Single storey side extensions and entrance porch. (This application may affect the setting of a Listed Building. This application affects the character and appearance of the Arundel Conservation Area).

75 Maltravers Street Arundel

Thank you for your internet representation made on 22nd January 2020 which has been recorded as '**no objection**' with the comments as follows:

Proposed Extension and Alterations
at Owls Hoot, Arundel
for Mr R Dowson & Ms S Harnett
Drawing P02 October 2019 Scale 1:100 @ A3
Planning Drawing - Ground Floor & Roof Plan & Elevations

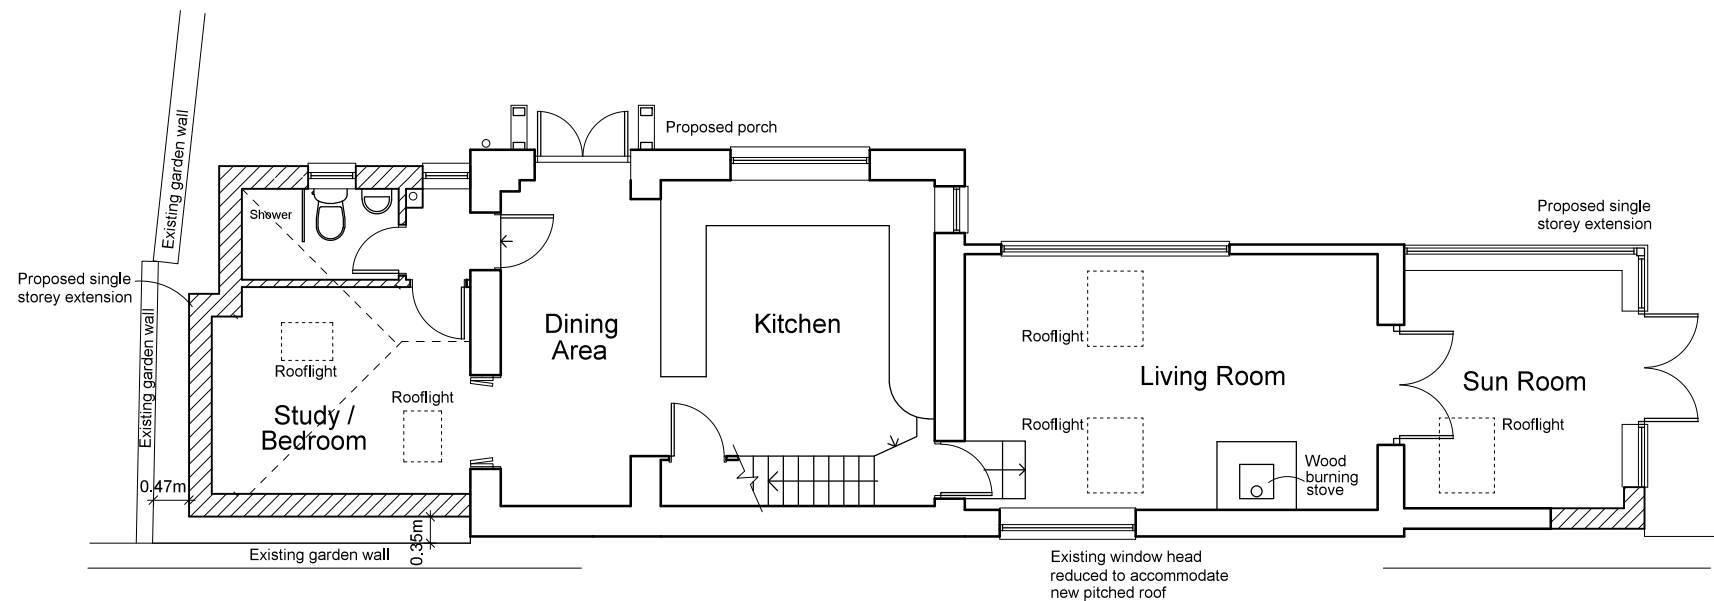
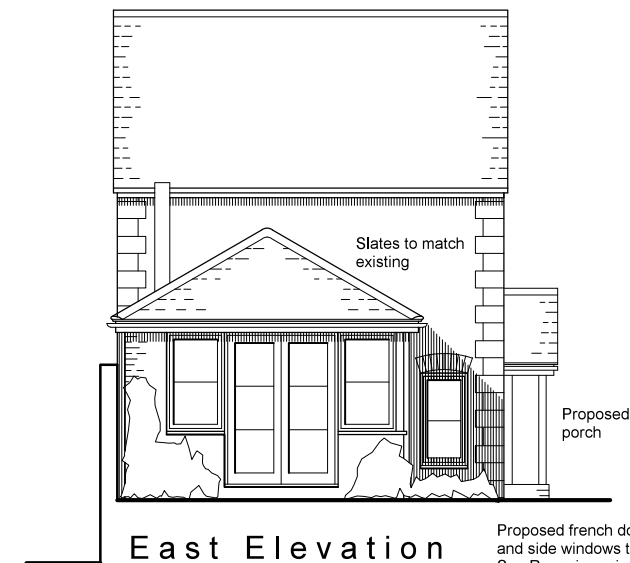
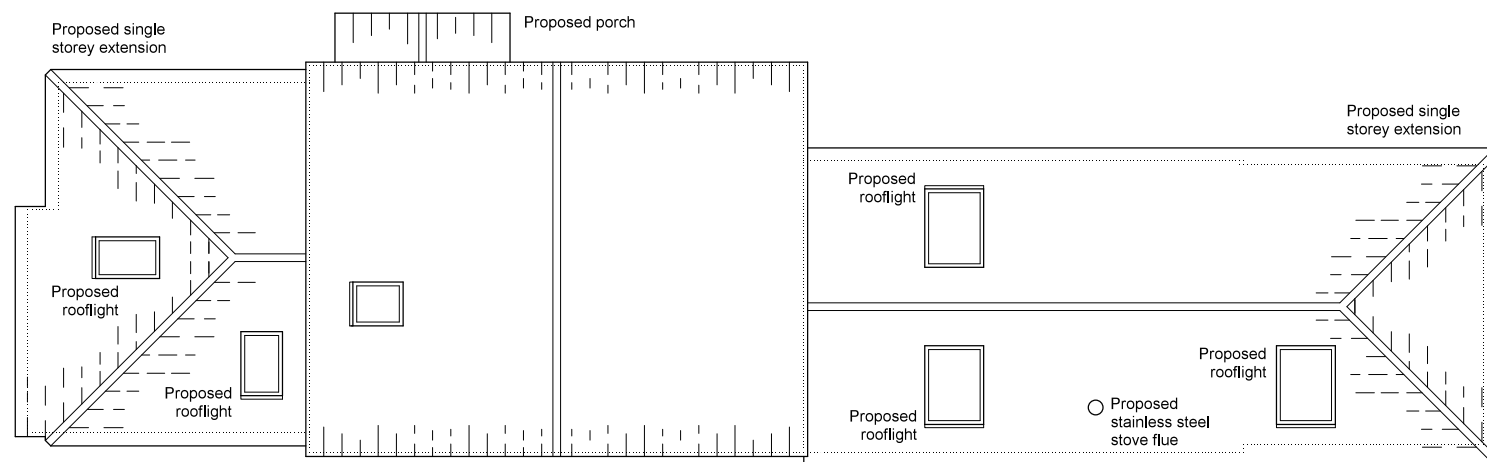
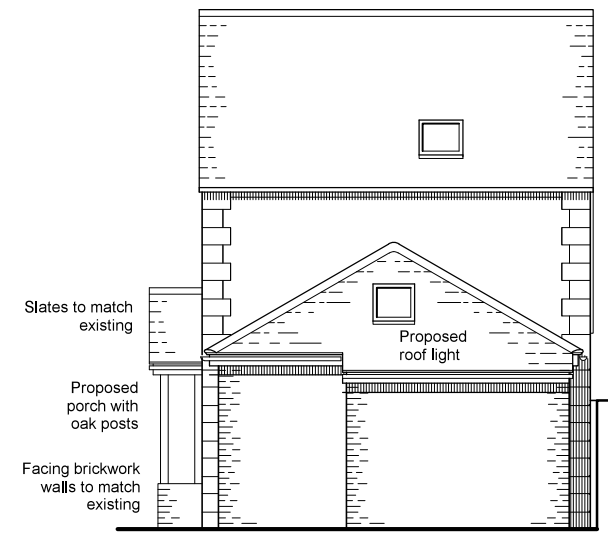
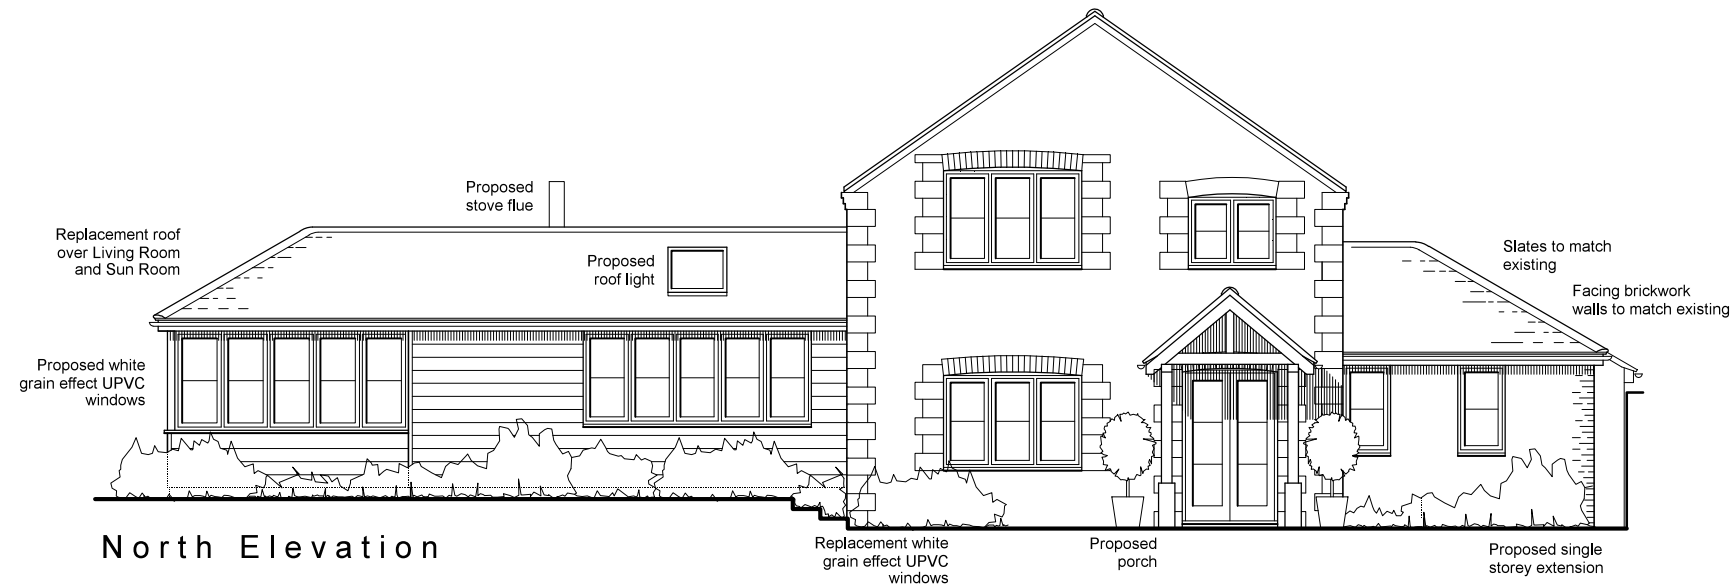
The Panel consider that the use of timber joinery would be more appropriate than pvcu and natural slates preferable to cement fibre slates in the historic area of the town. All the roof lights need to be conservation style and the appearance of the larger ones would be improved with the introduction of central vertical glazing bars. It is also recommended that the proposed stove flue pipe should be painted black to provide a more appropriate appearance to the original building form.
